**Re: SSD-73761707 Glendenning Road Data Centre – 2 Glendenning Road, Glendenning NSW
 Response to Stormwater Matters Raised by Greater Sydney Parklands**

Further to the Greater Sydney Parklands (GSP) Advice letter dated 30 June 2025 relating to the Environmental Impact Statement (EIS) submitted for the above State Significant Development Application (SSDA), this technical memorandum has been prepared by ACOR Consultants Pty Ltd (ACOR) to respond to stormwater matters within the GSP advice letter.

Figure 4-2 Existing conditions 1% AEP flood levels and depths (extracted from Blacktown City Council, 2016)

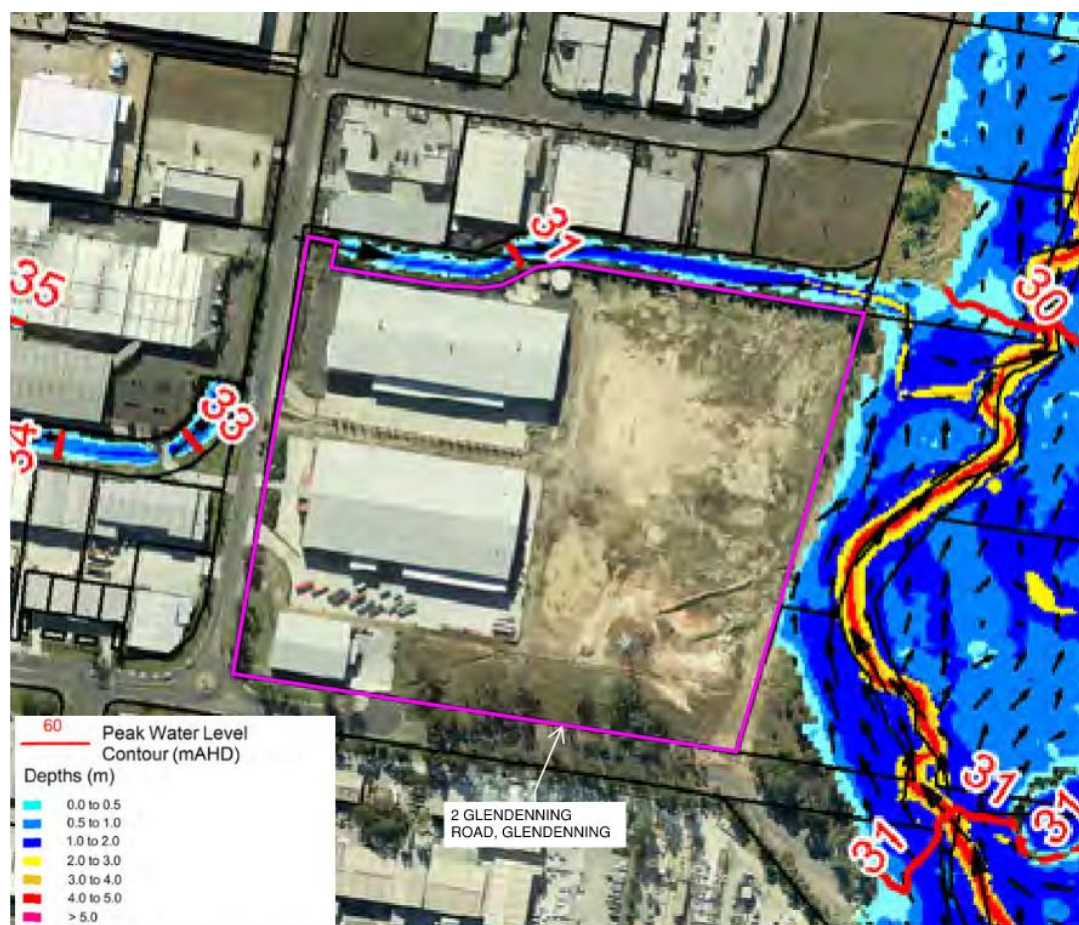
While the site is in a location that is exempt from stormwater detention under Council’s controls, further information is requested on the existing and future quantity and quality of overland flow to avoid impacts on Western Sydney Parklands.

In regard to overland flows generated from the proposed development and north-eastern headwall discharge, the Eastern Creek Catchment Development Scenario Hydraulic Assessment (Blacktown City Council, 2016) report was reviewed for the site location to determine the flood affectation and characteristics near the site.

Flood mapping undertaken for existing conditions as part of the Eastern Creek Catchment Development Scenario Hydraulic Assessment (Blacktown City Council, 2016) show that the 1% AEP and 0.2% AEP flood events do not directly impact the site. In these events, flood water is contained within the drainage channel to the north of the lot and in Eastern Creek (external to the lot) to the east.

The Eastern Creek Catchment Development Scenario Hydraulic Assessment indicates that there is sufficient capacity of the existing drainage channel to the north of the site to convey the 1% AEP and 0.2% AEP flows from the upstream catchment including the proposed development.

Whilst there will be an increase in peak flow rate from the site due to an increase in impervious area by the development, the Eastern Creek Catchment Development Scenario Hydraulic Assessment indicates that there is sufficient capacity to contain flows, particularly as the flood modelling undertaken does not include provision for on-site detention (OSD) for the site as part of the flood model.

Impacts to the GSP land directly to the east due to any increase in site flows will be negligible as it represents a small fraction of total flows from the upstream catchment.

Thus we consider that the position of the north-east stormwater outlet and the overland flows generated through the existing drainage channel to have negligible impact to the existing overland flow paths through GSP land.
